From: [Pat Nicholson](#)
To: [Rachael Stevie \(CD\)](#)
Subject: RE: BL-20-00003 Wallace - Notice of Application
Date: Thursday, February 13, 2020 6:15:02 PM
Attachments: [image001.png](#)

From: Rachael Stevie (CD) <rachael.stevie.cd@co.kittitas.wa.us>
Sent: Thursday, February 13, 2020 5:00 PM
To: Pat Nicholson <pat.nicholson@co.kittitas.wa.us>; Candie Leader <candie.leader@co.kittitas.wa.us>; Holly Erdman <Holly.erdman@co.kittitas.wa.us>; Jesse Cox <jesse.cox@co.kittitas.wa.us>
Cc: Lindsey Ozbolt <lindsey.ozbolt@co.kittitas.wa.us>
Subject: BL-20-00003 Wallace - Notice of Application

Please review the following Boundary Line Adjustment application submitted by Dustin Wallace (BL-20-00003). Any comments need to be submitted by 5pm on February 28, 2020. Please let me know if there are any questions.

PROPOSED
\$ Site Plan

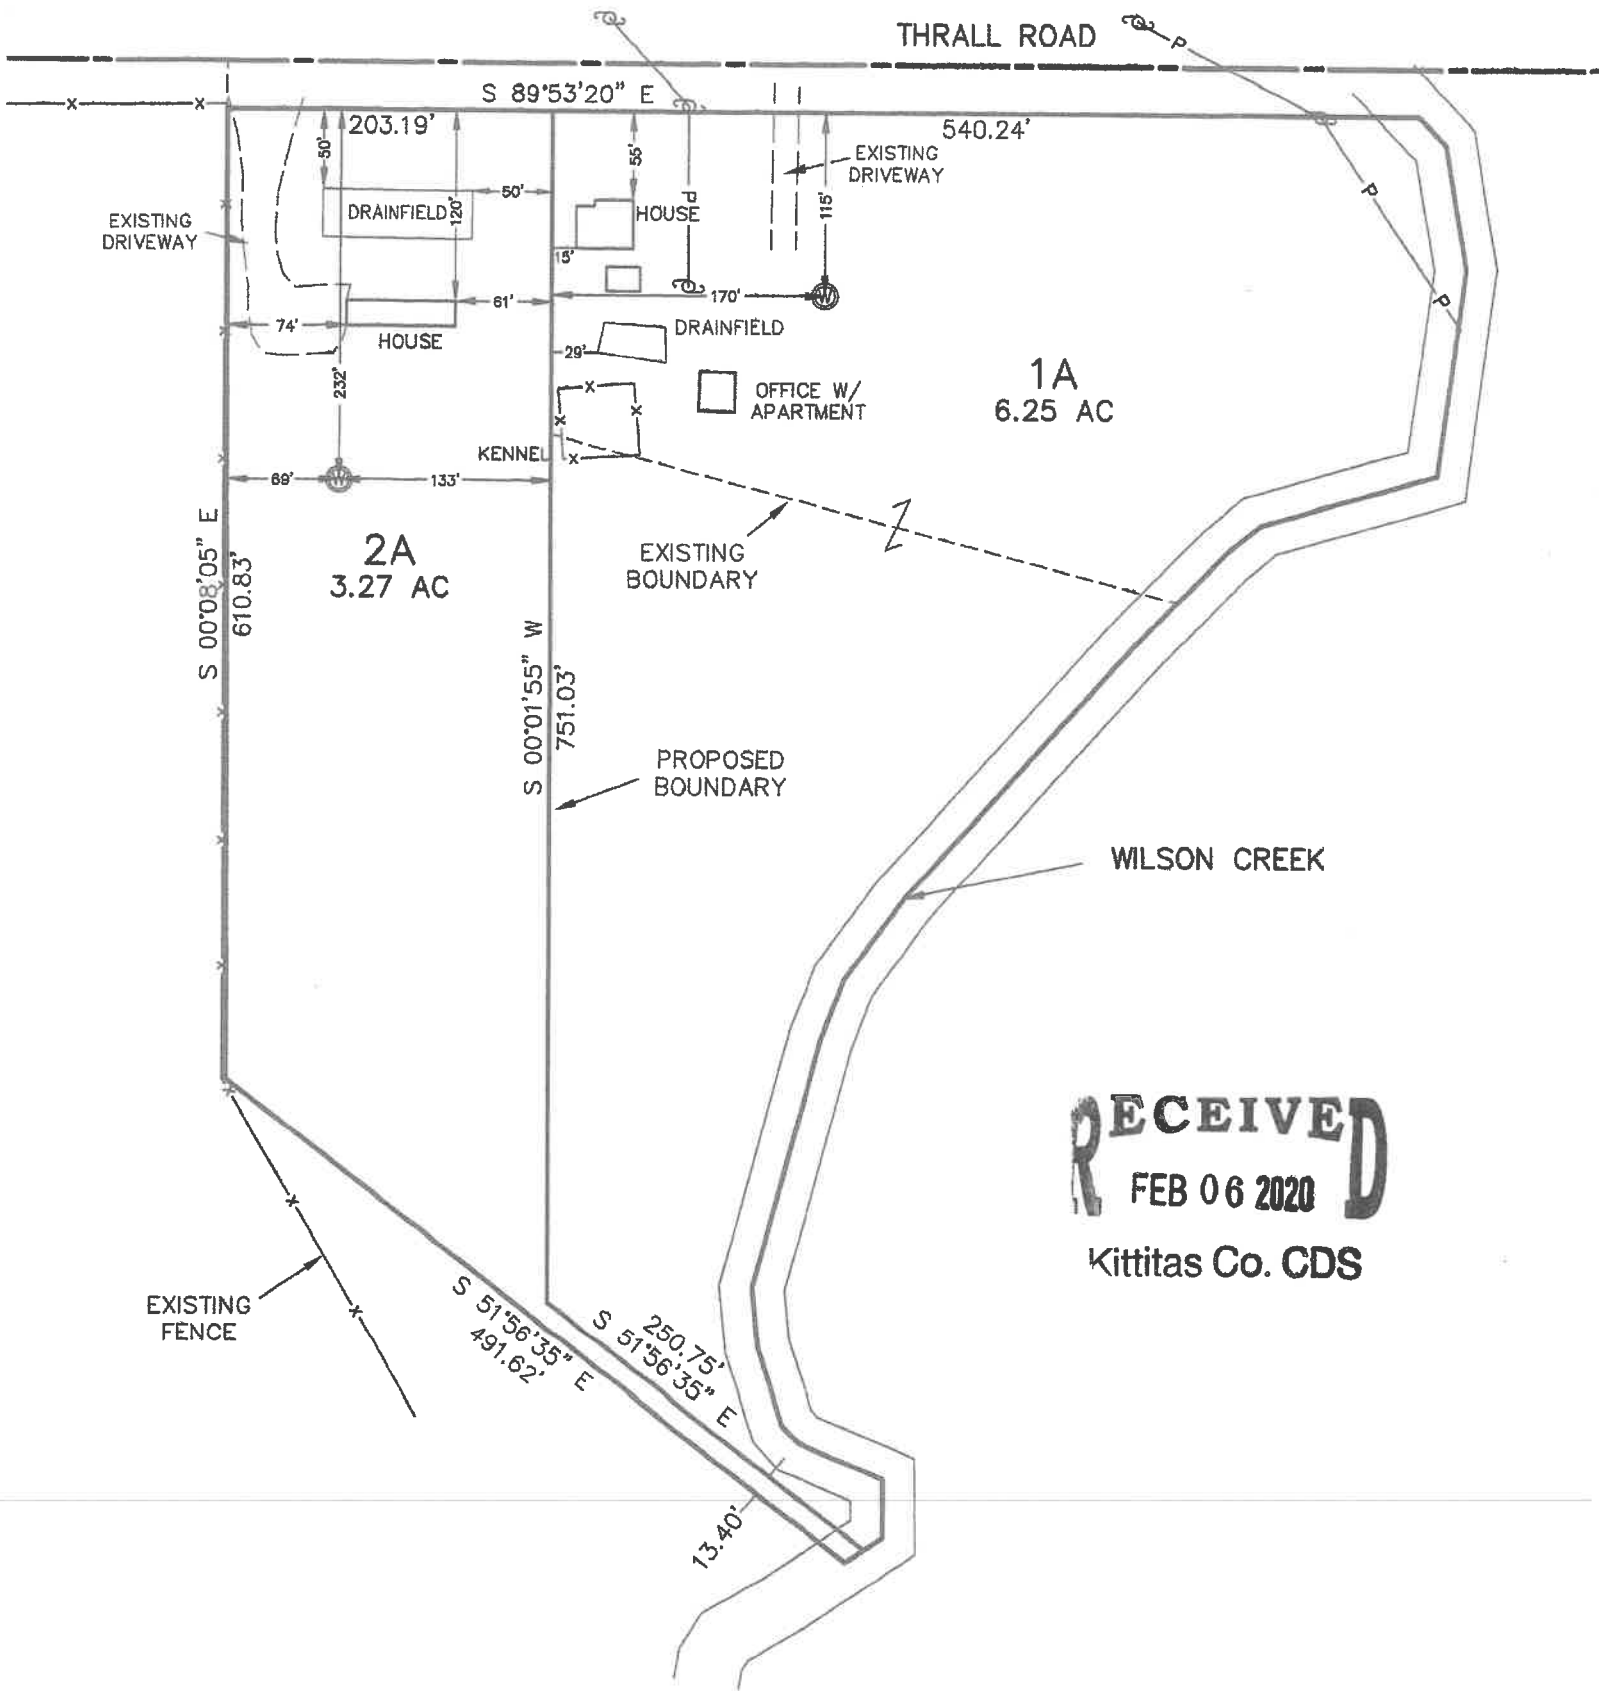
Both accesses to meet current PW and IFC standards.
